Jean Fraser - RE: FW: 13105-133 York Street

From: Barbara Barhydt
To: Greer, Tom
Date: 8/30/2013 1:22 PM
Subject: RE: FW: 13105-133 York Street
CC: Benn, Jeremy; Flynn, Joe; Fraser, Jean

This project is to demolish an existing (abandoned) two family dwelling and to replace it with a 6 residential condominium. The project is in the R-6 zone and uses the regular R-6 zone dimensional requirements. However, because the existing building is on the existing rear property line, the rebuild is able to be moved forward and use section 14-433 to allow building additions to be within 5' of the side and rear line for buildings existing as of July 19, 1988. The existing building was present well before that date. The required front setback is being met.

1
A-202
NORTH ELEVATION
SCALE: 1/4"=1'-0"

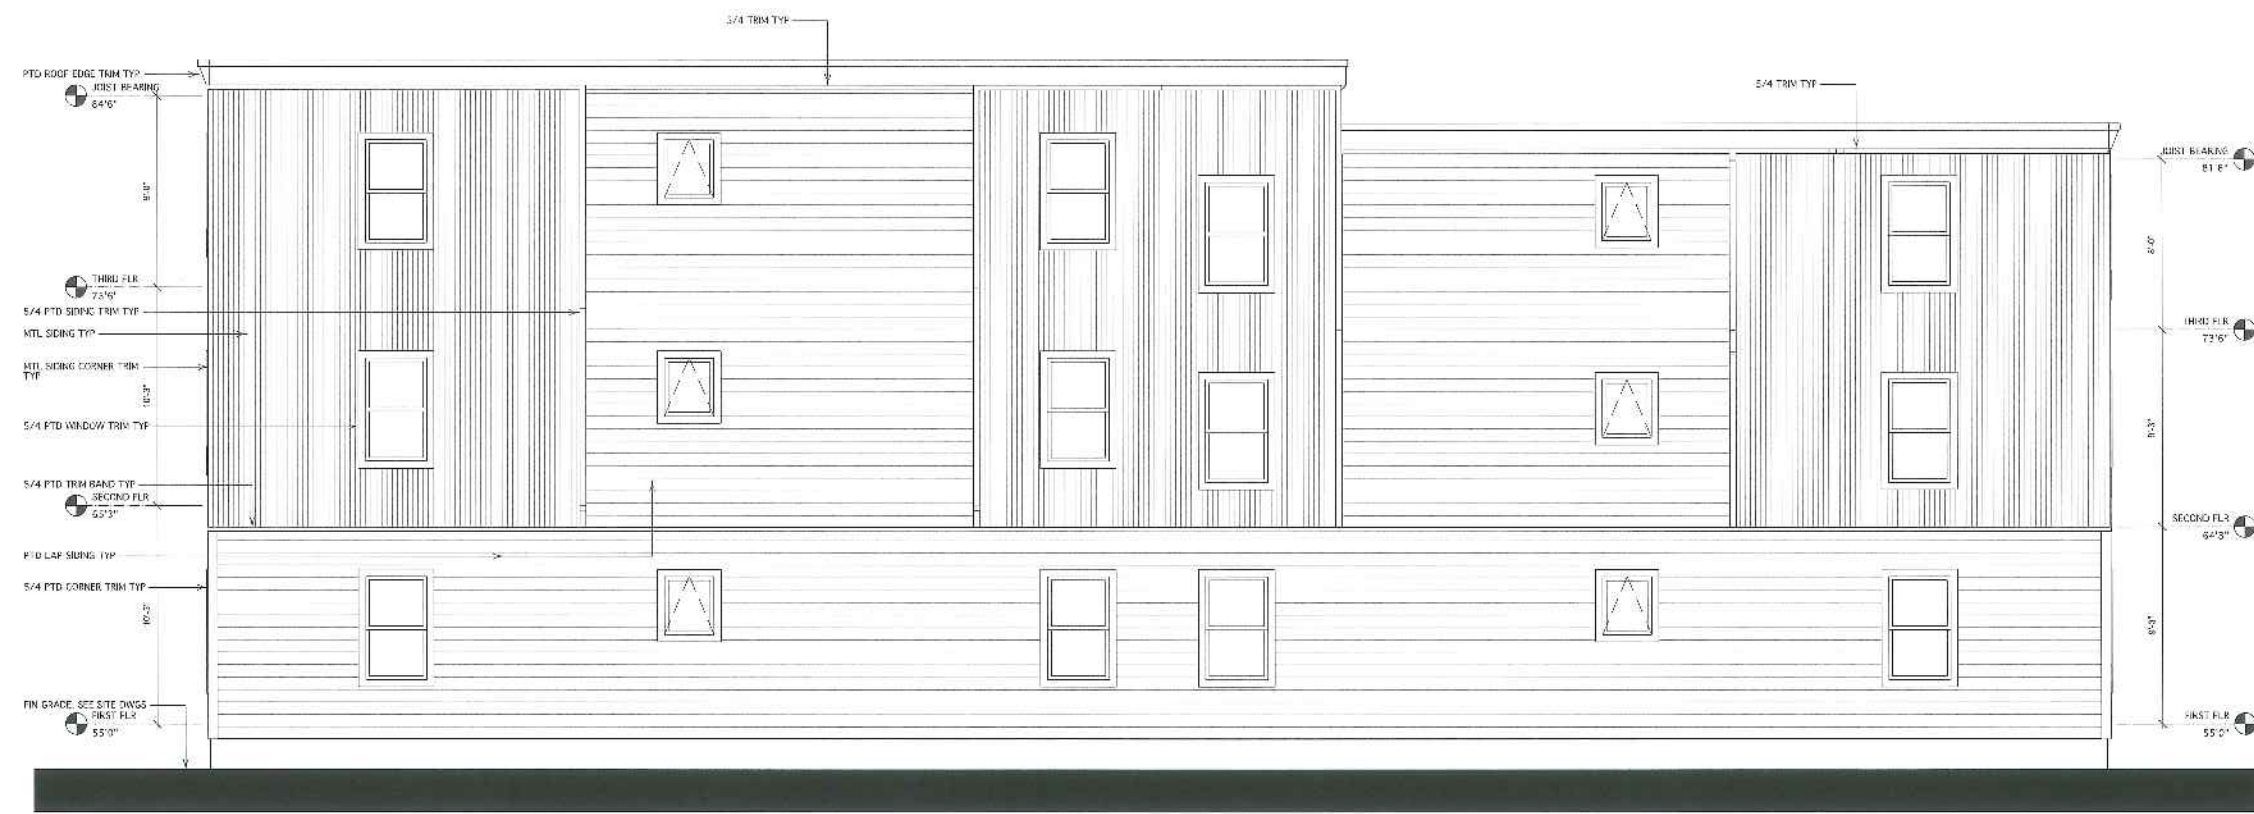
The building height is being met (under 45'). However, the dimensions are being shown to the joist bering and not to the top of the joist as required by definition. I would like to see revised drawing that show the building height from grade (or average grade) to the top of the roof beam.
